ITEM 3.2 (c2)

Issue/ Objection:
Views

85 Harrington Street

RESPONSE TO DoPE

Four Seasons View Analysis

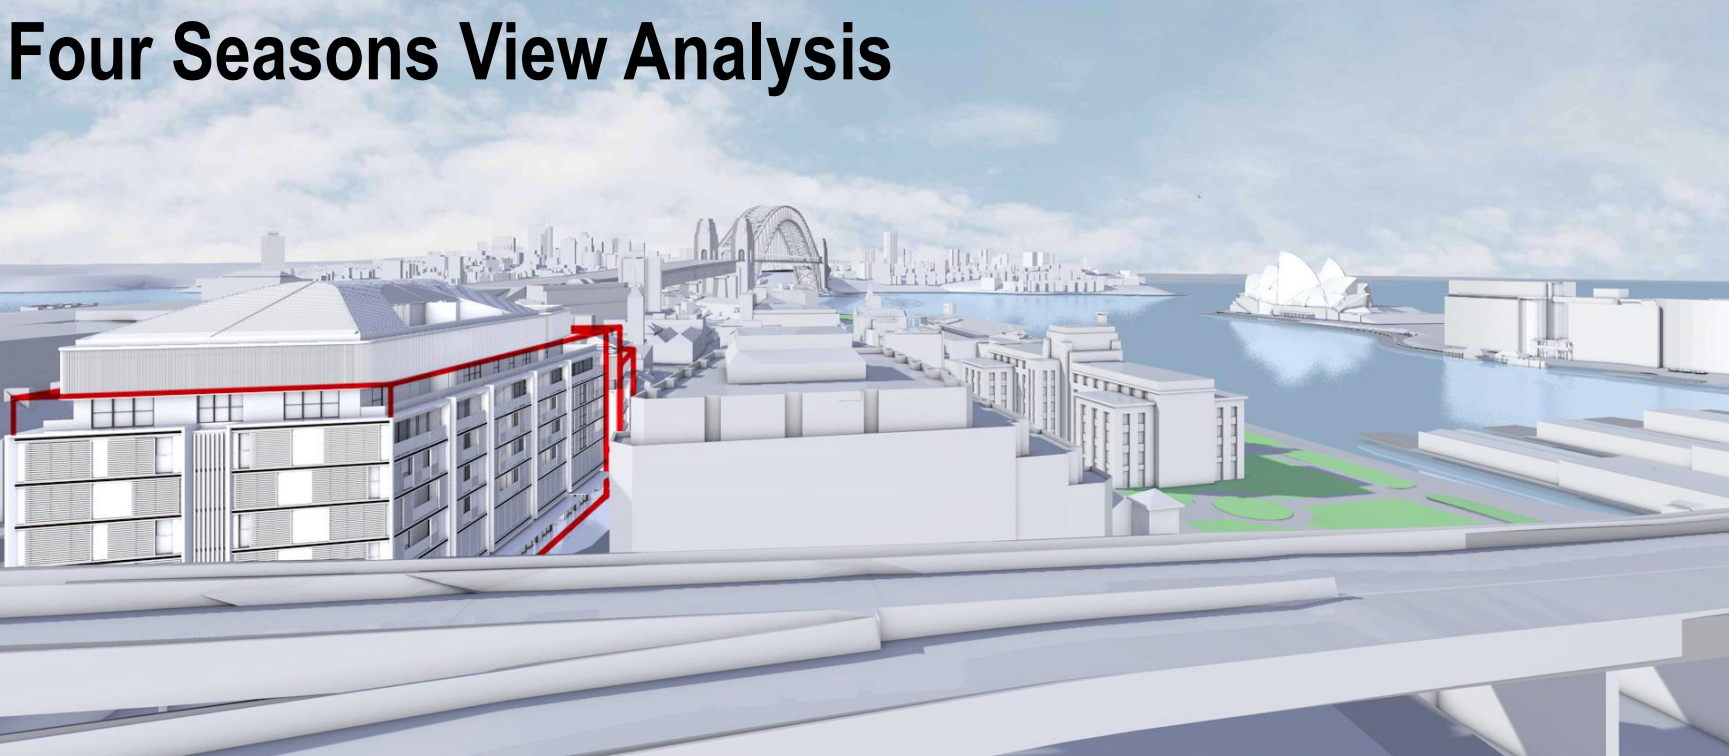
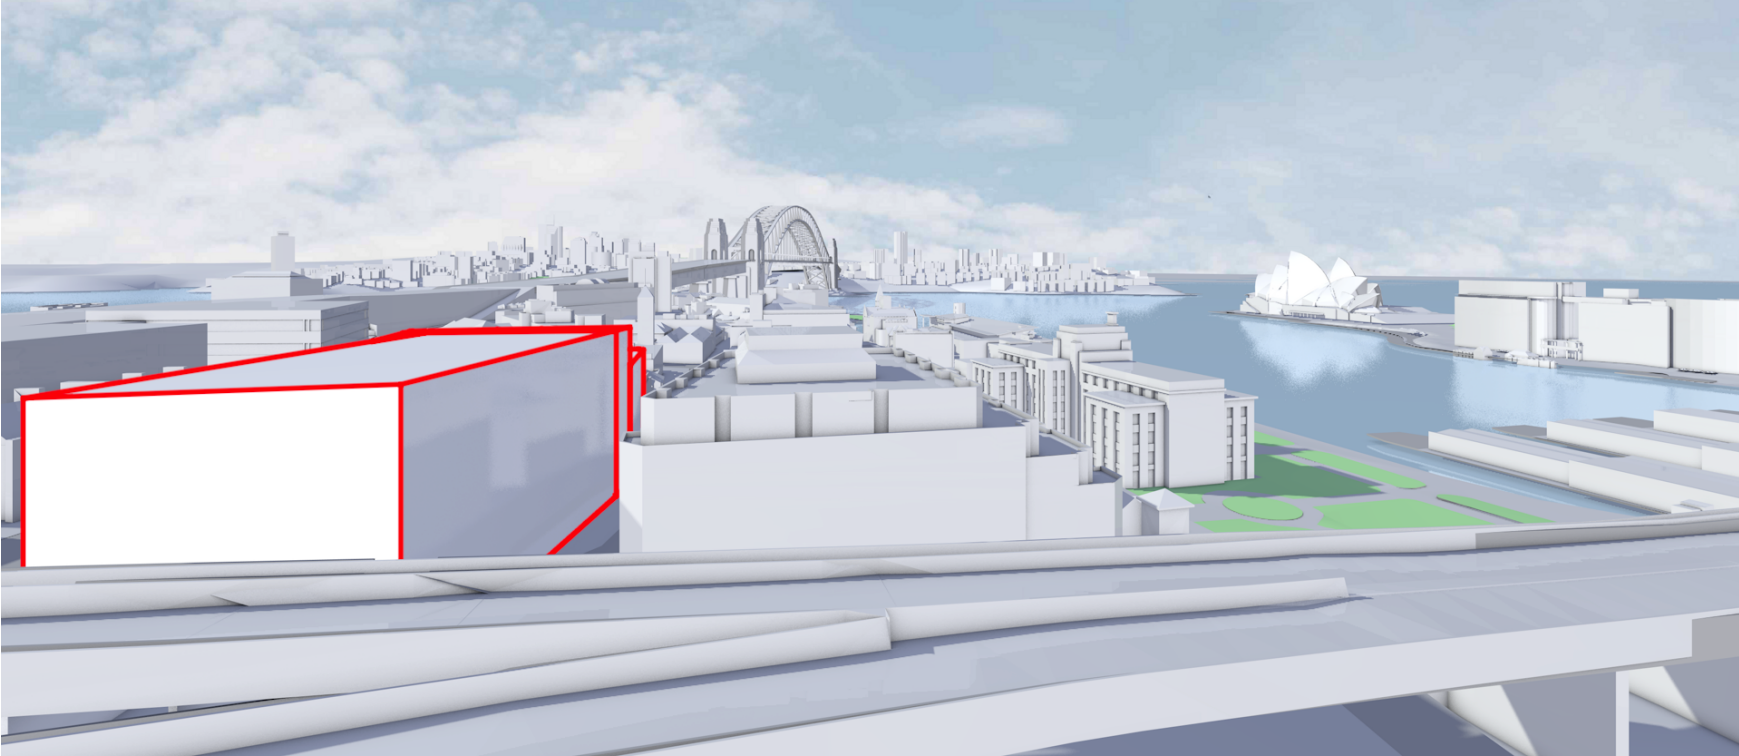
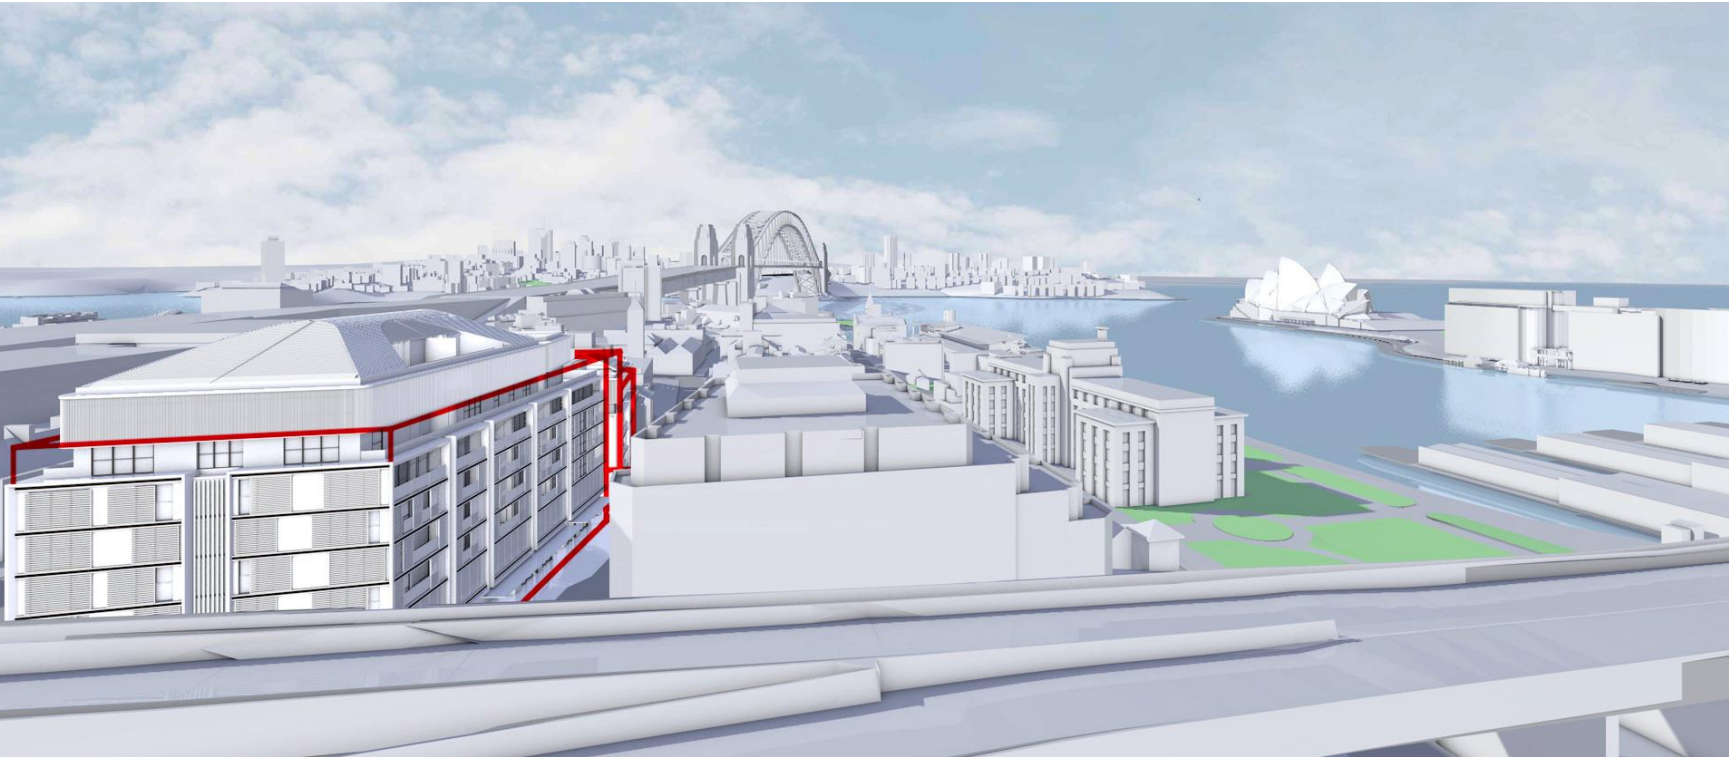
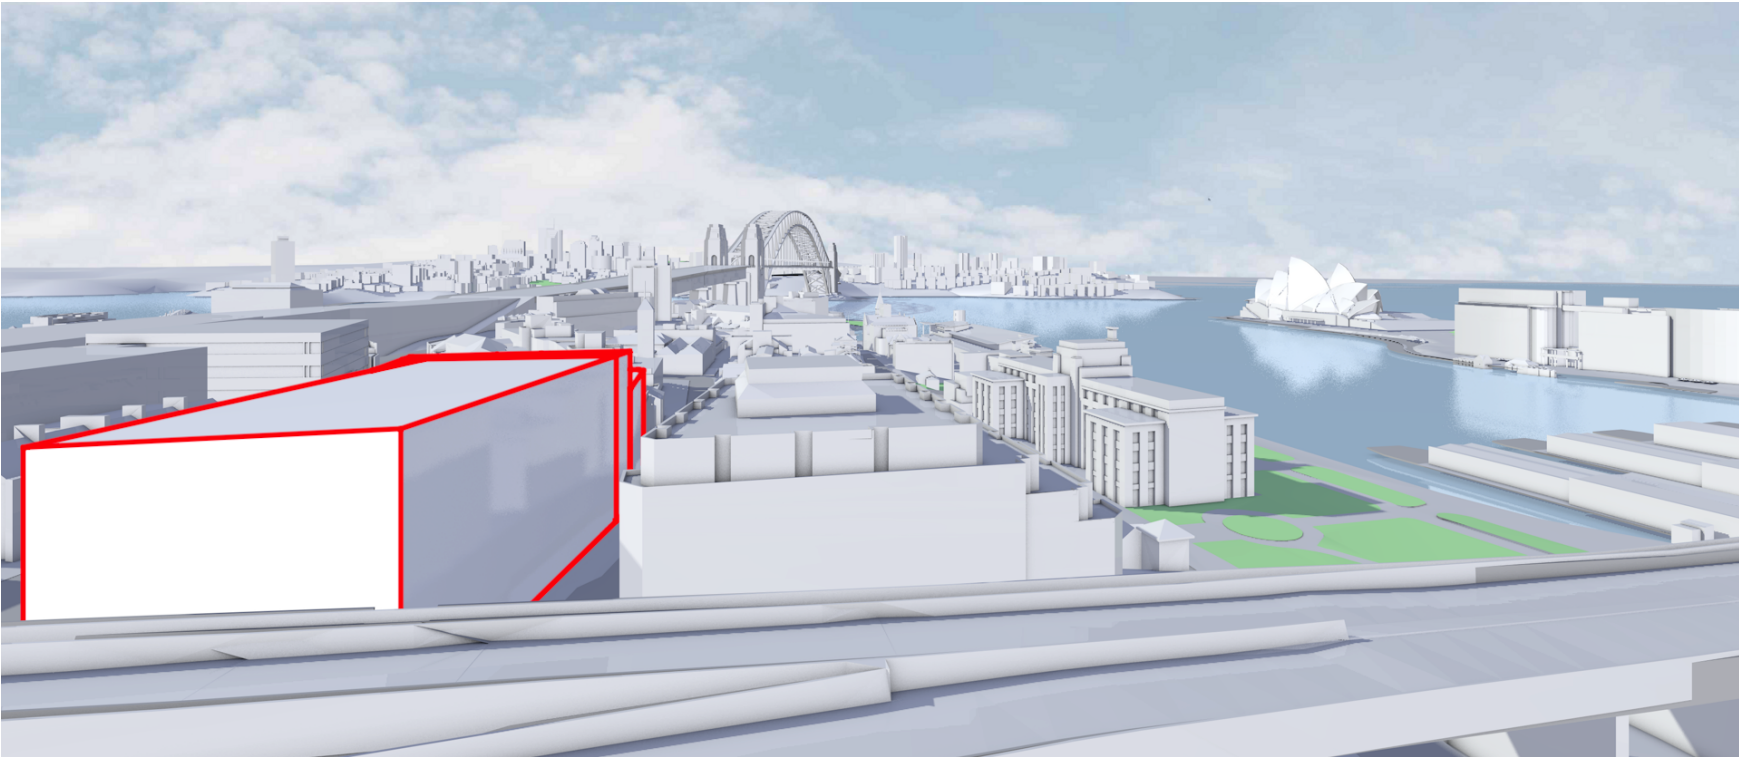
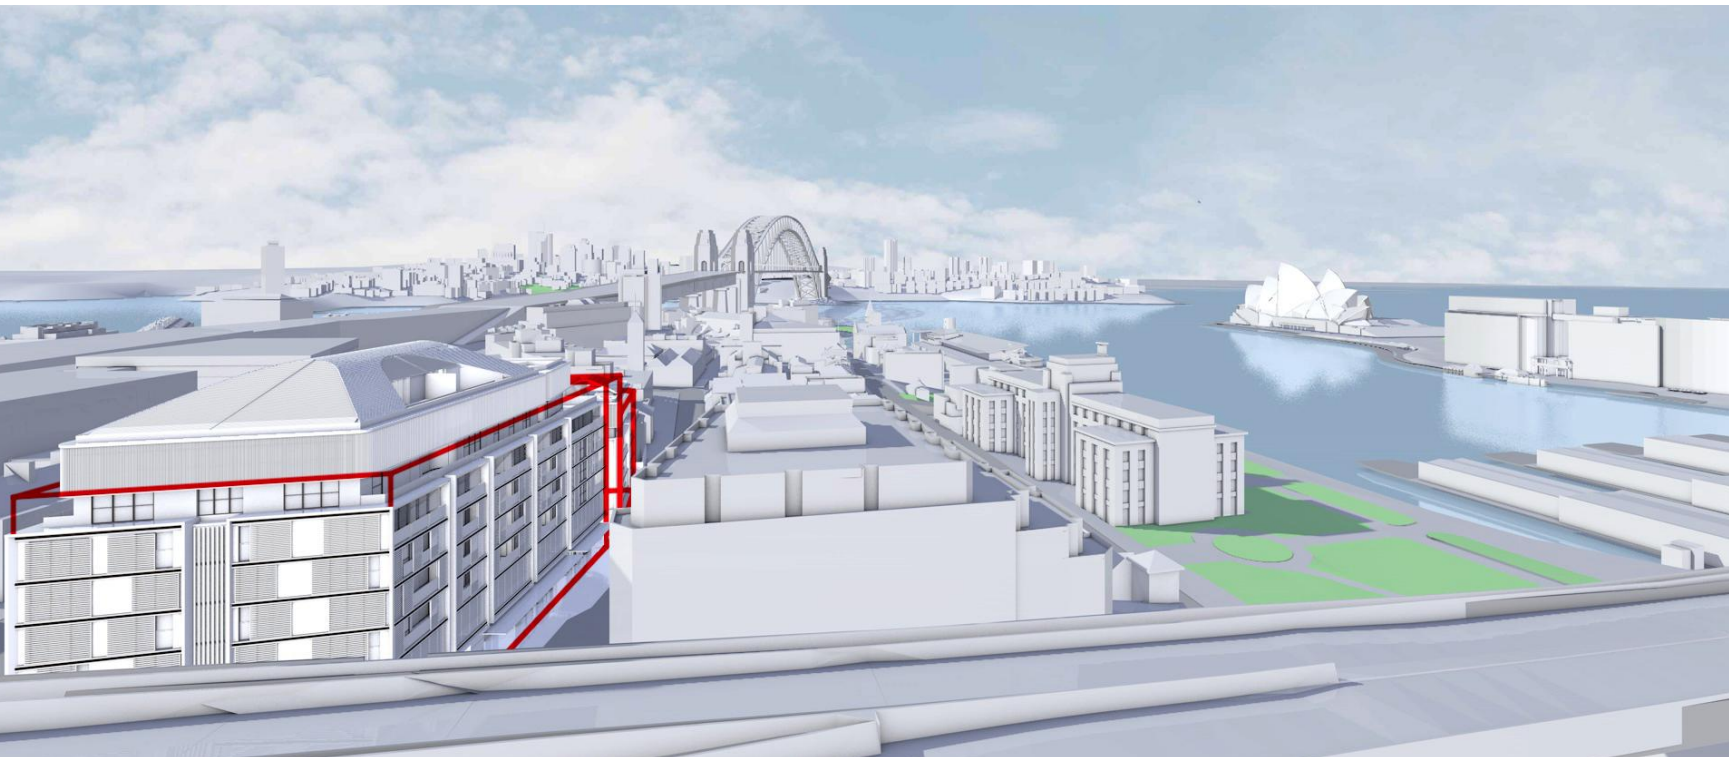
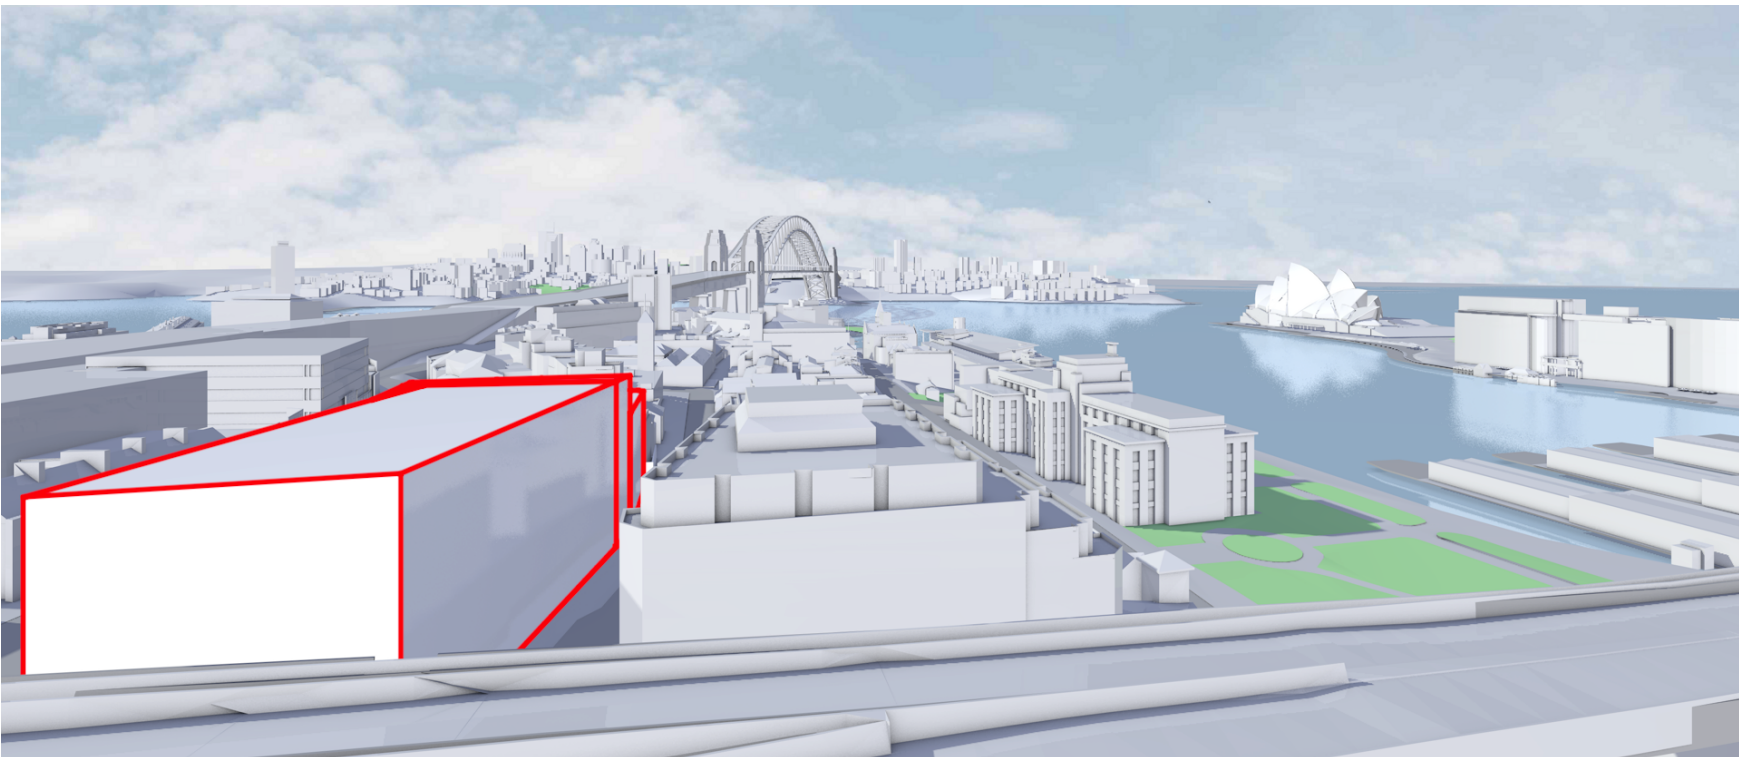
Description:
Please provide revised and enlarged images illustrating view impacts from a SCRA compliant scheme and separate comparison images illustrating views impacts from the proposed scheme. Please also state the RL/level within the building the views are taken from and whether views from permanent residential units within Quay West are potentially impacted by the proposed development.

Response
Updated diagrams showing impacts from a SCRA compliant scheme and the proposed development have been provided. The images have been enlarged, with approximate RLs provided for each of the view diagrams.

- 1Commercial office stratum lot – from GL to L7
- 2Midrise – Quay West Suites (hotel) – from L8 to L23
- 3Viewing Deck/Communal amenities on L24
- 4High Rise – Permanent/owner occupiers – from L25 to L38 (top).

Based on information received from the strata manager of the Quay West, there will be no impact to permanent resi as they start from L25
